May 23, 2017

**Subject: 1039 Riverside Street, Second Tee Business Park Unit 15
Final Site Plans
Letter of Response #3**

SHEET TITLE
**GRADING, DRAINAGE AND
EROSION CONTROL PLAN**

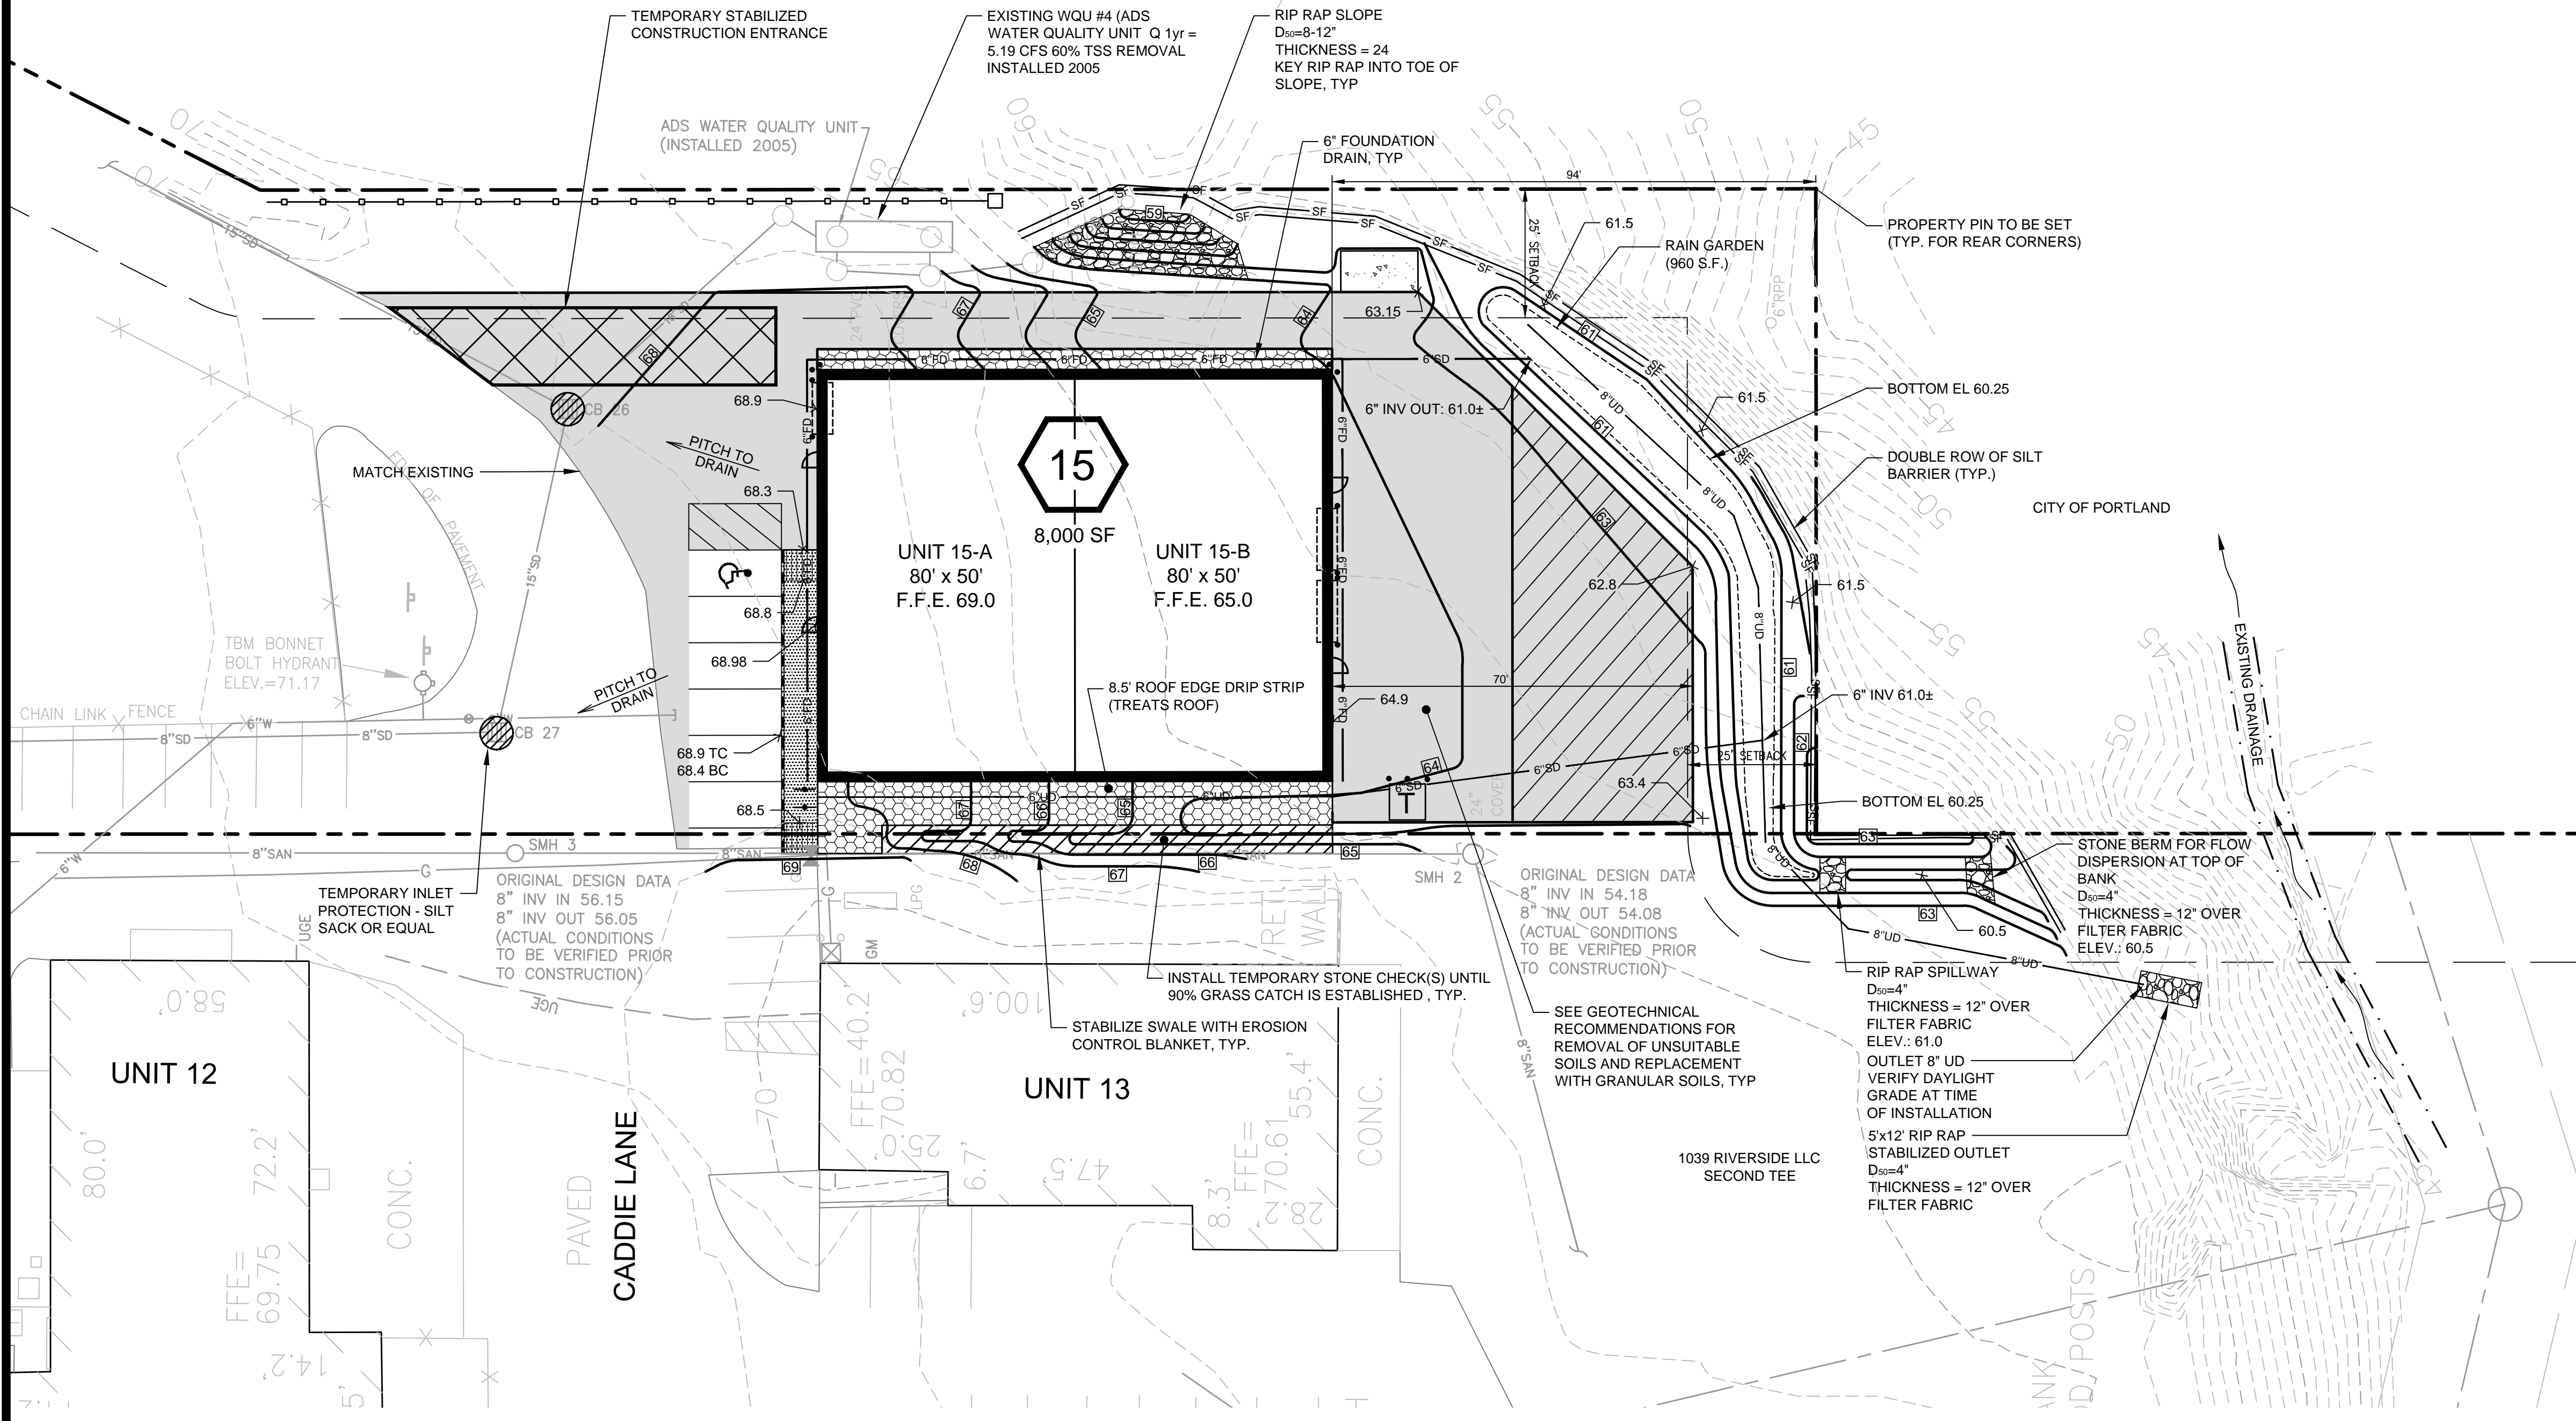
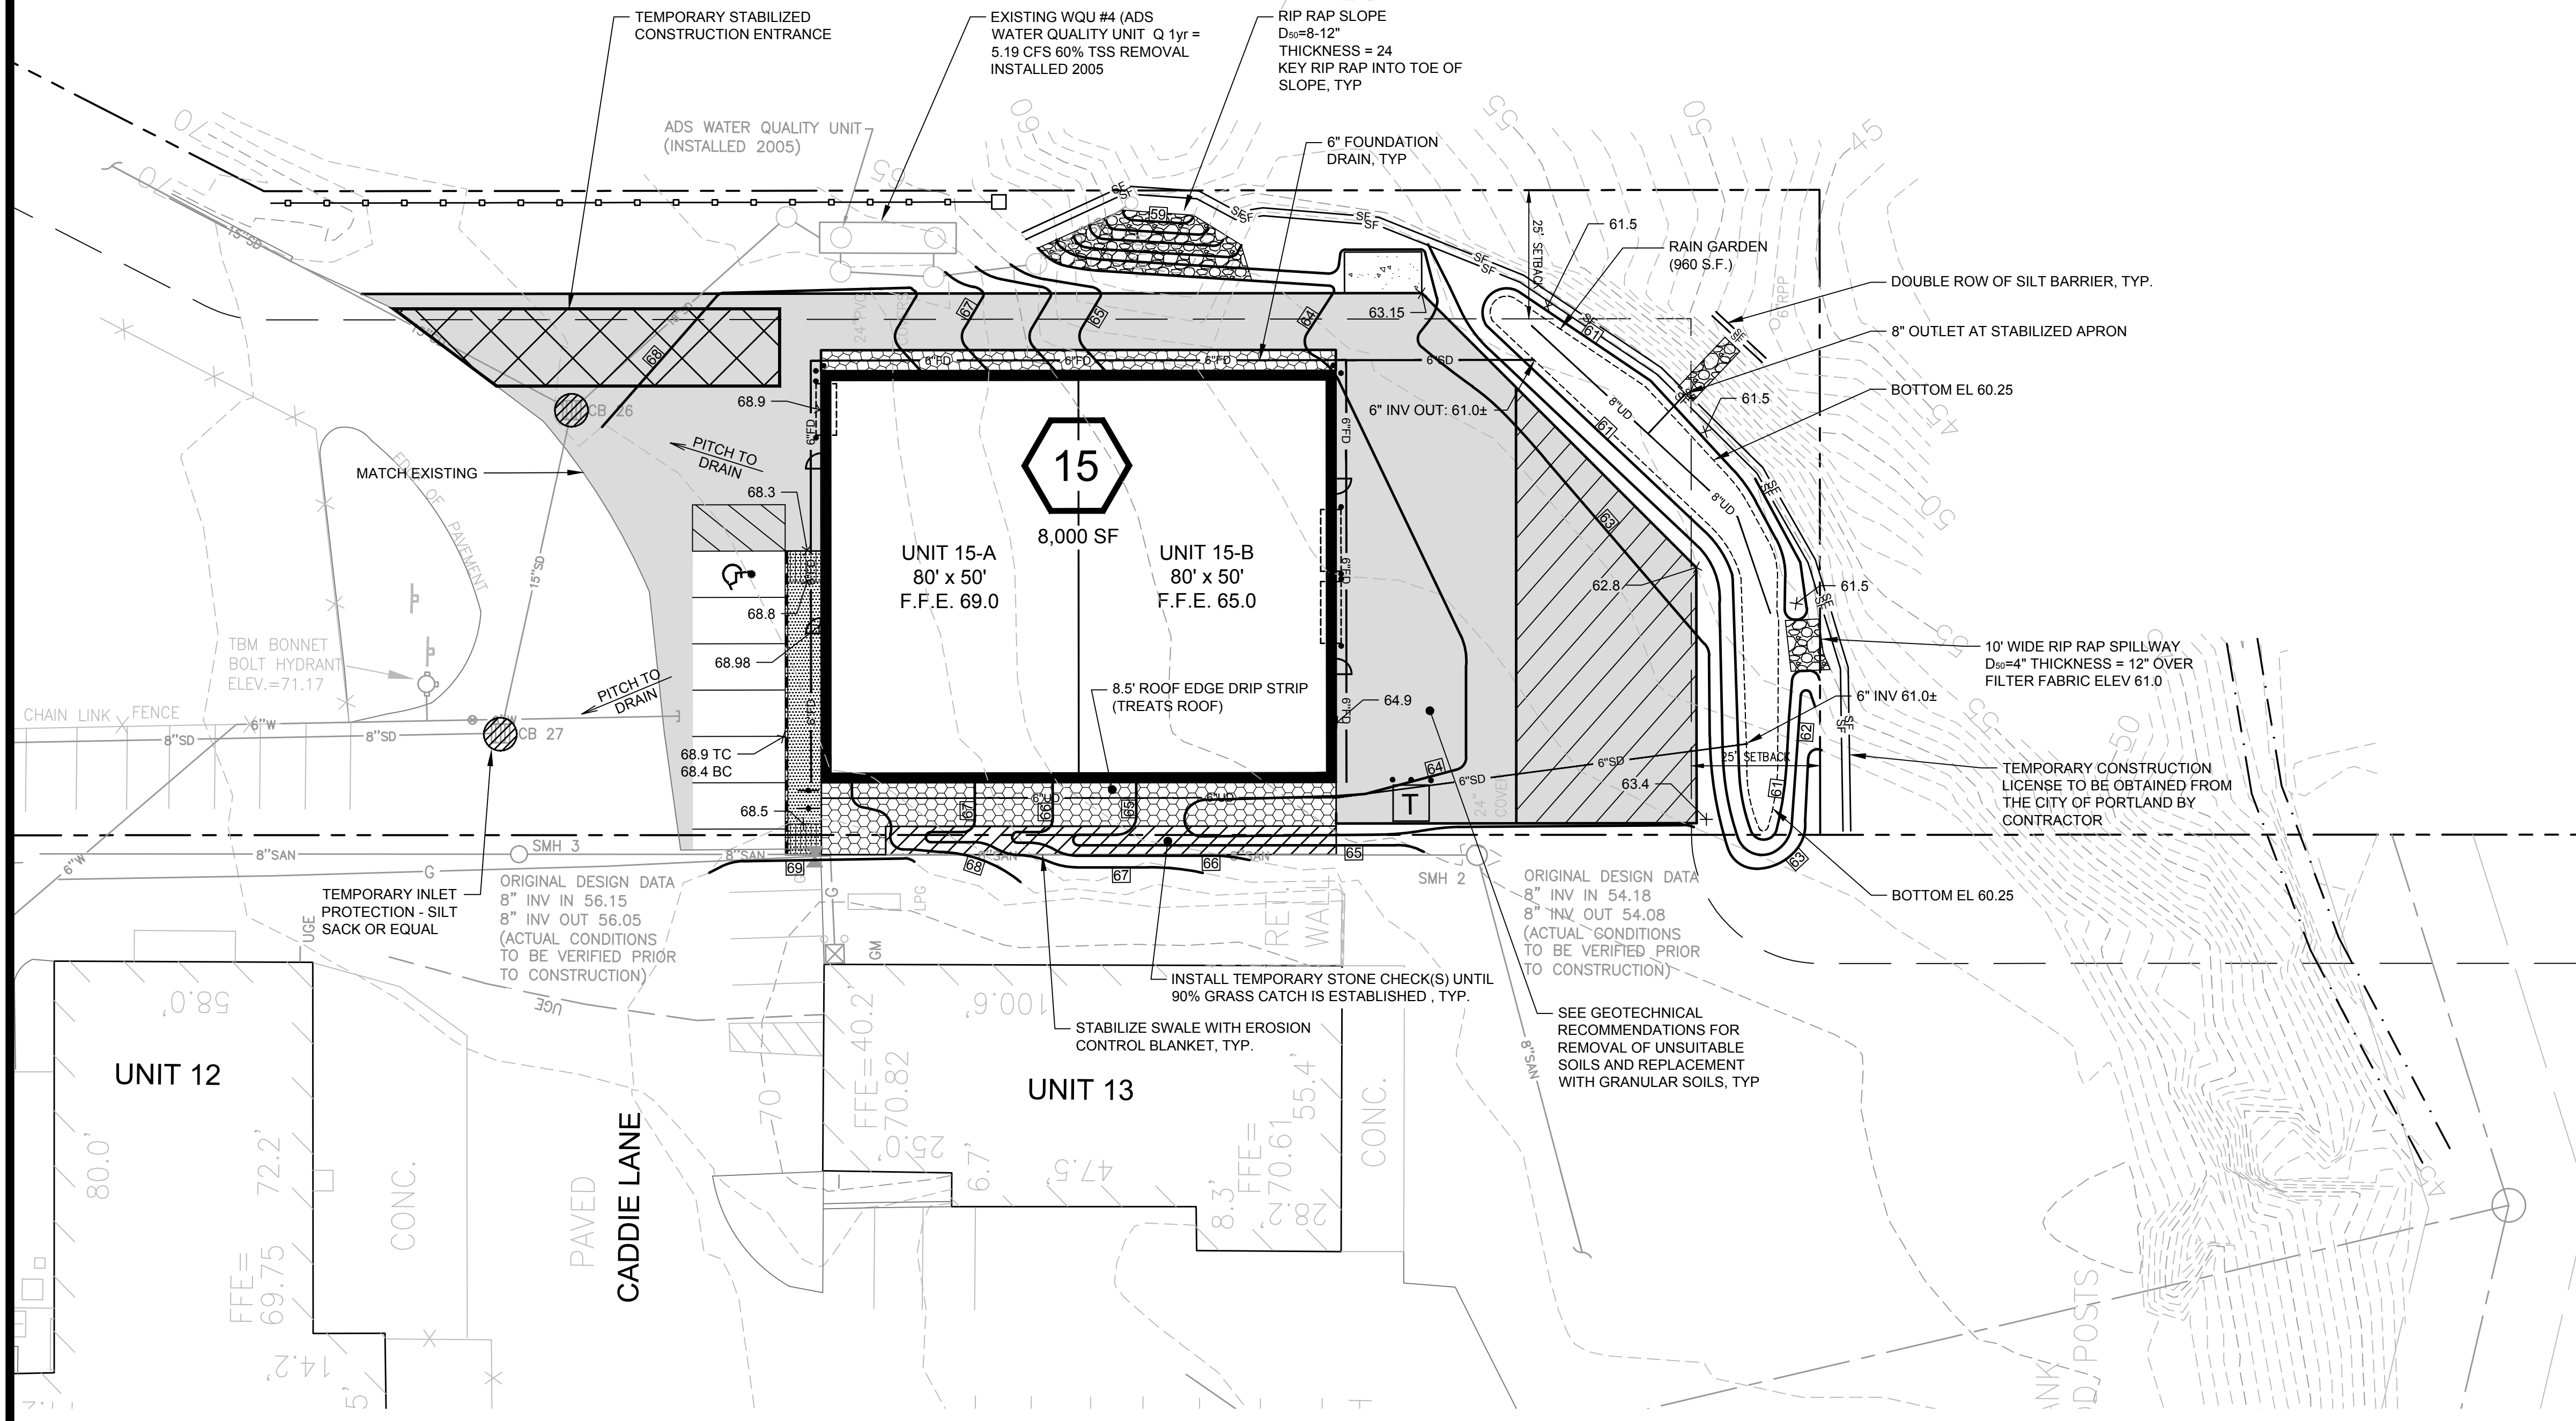
As a follow up to our phone discussion yesterday, I offer the accompanying revised Grading, Drainage and Erosion control plan that details the installation of the rain garden at the rear of the Unit 15 site. We've modified the grading a bit to redirect the outfall from the rain garden such that it remains within the 1039 Riverside LLC land area and avoids the UD or overflow discharges directly to the adjacent city land. This will involve a shallow swale to be constructed just north of unit 10. We've redirected the 8" UD from the rain garden also so it discharges onto the slope behind Unit 10, which is a common area within the condominium.
